## MEMORANDUM

**TO:** Nell Donaldson, Planner  
**FROM:** David Senus, P.E. & Ashley Auger, E.I.T.  
**DATE:** August 2, 2013  
**RE:** Bay House Phase II, Preliminary Level III Site Plan Application

Woodard & Curran has reviewed the Preliminary Level III Site Plan/Subdivision Application for the proposed second phase of the Bay House development located on Newbury Street in Portland, Maine. The project consists of development of a 39 unit, four story residential building.

**PAVEMENT SAW CUT DETAIL**  
NOT TO SCALE

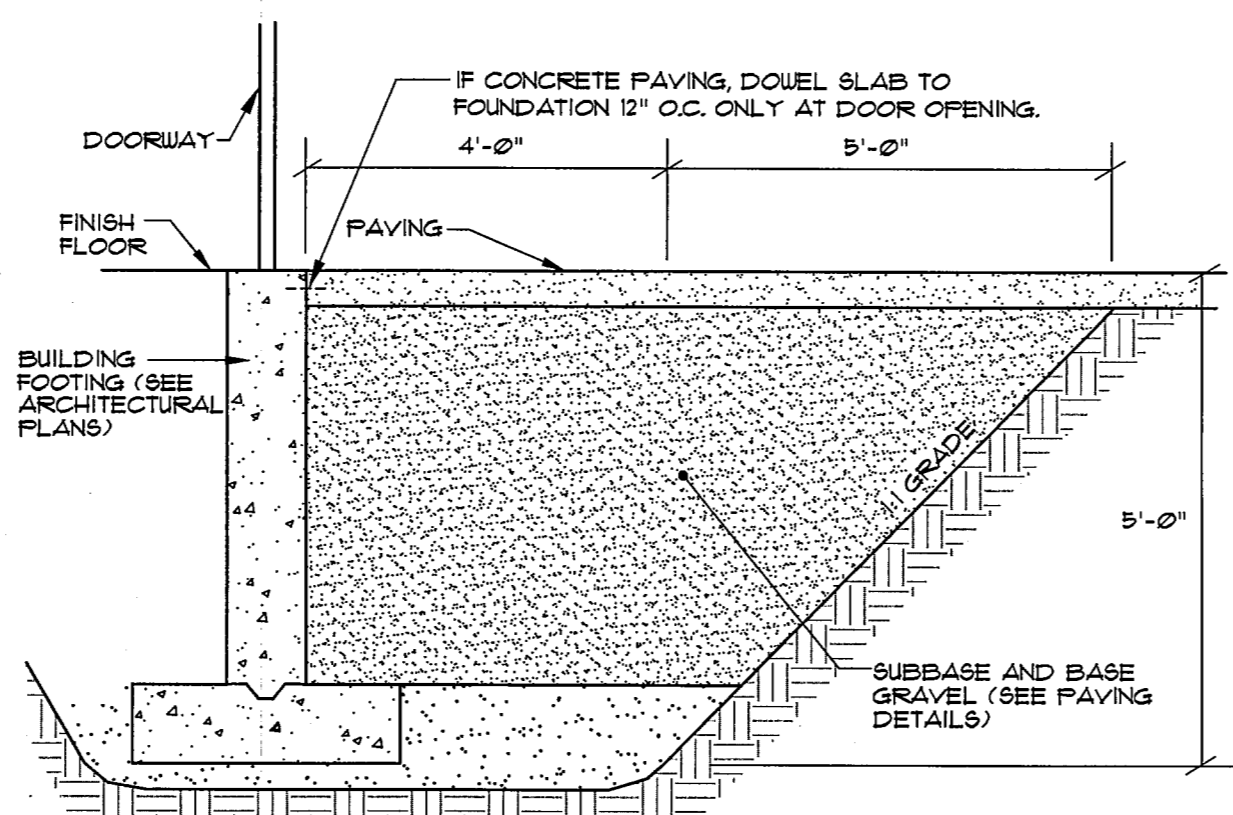
- 3) The final plans should note the material of all proposed stormdrain piping.
- 4) Sawcut limits should be depicted around the proposed storm drain pipes in Newbury Street.

**TYPICAL PIPE INSTALLATION DETAIL**  
NOT TO SCALE

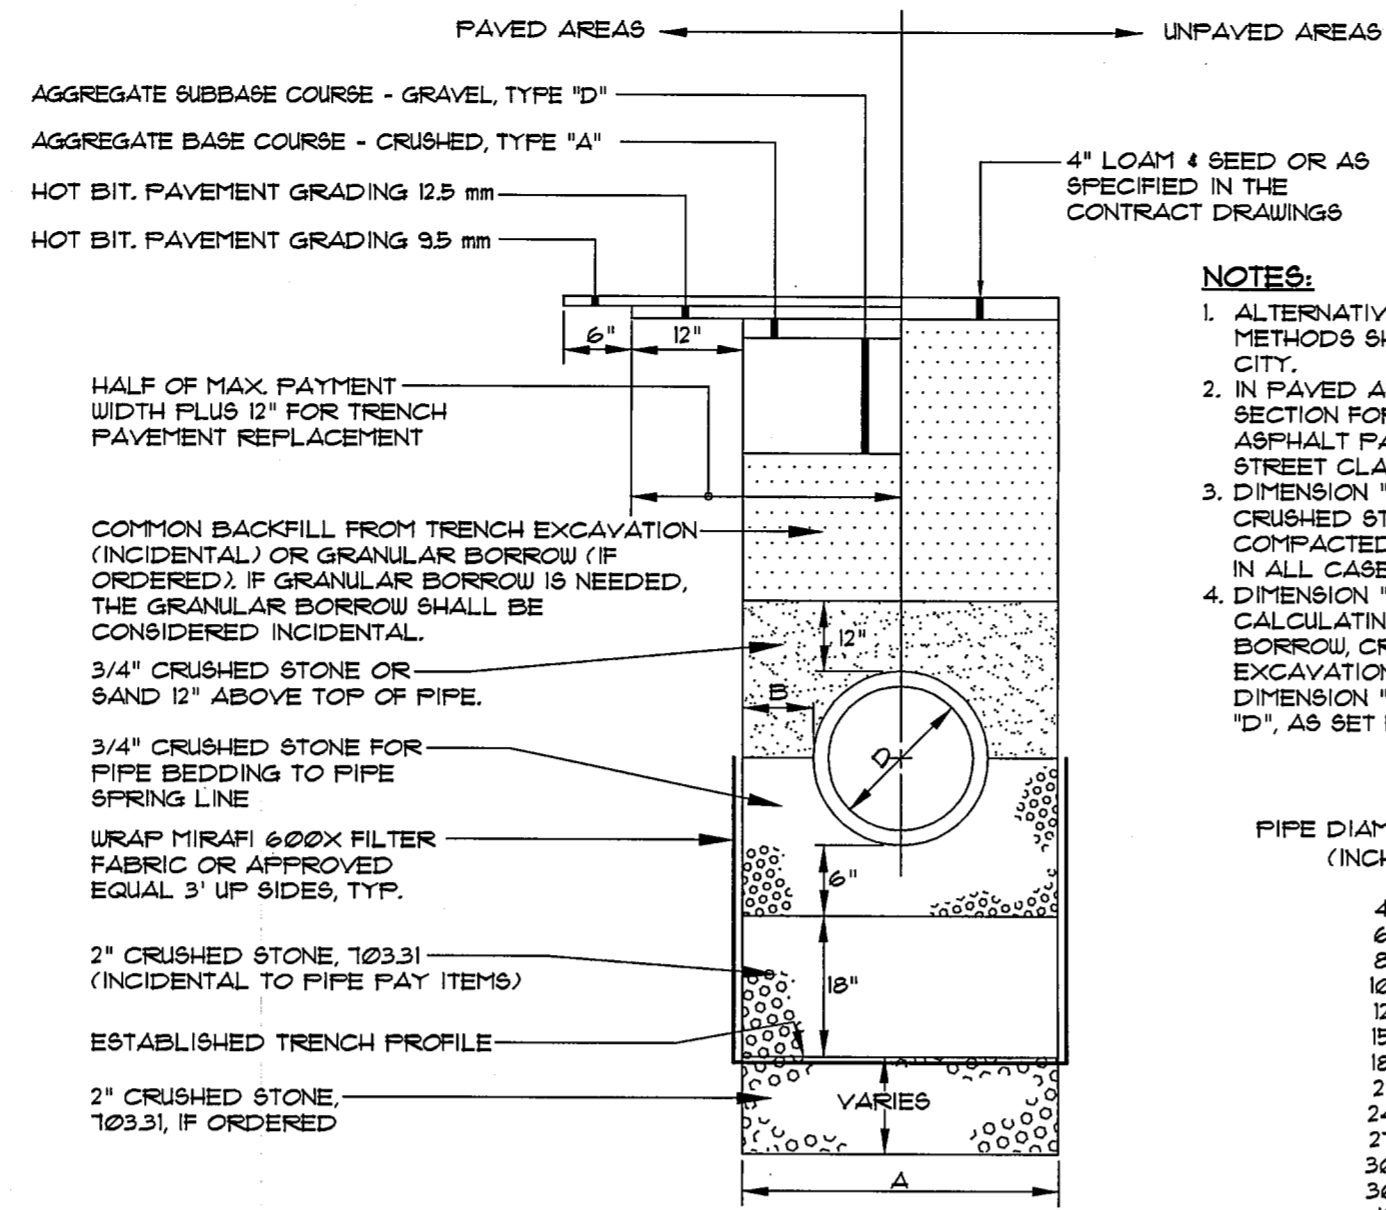
- 5) Final plans must be stamped by a professional engineer (Section 14-527, sub-section (e) of the City of Portland Land Use Ordinance).
- 6) The Typical Pipe Installation Detail should match Figure II-12 of the City of Portland Technical Manual for work within the Right-of-Way.
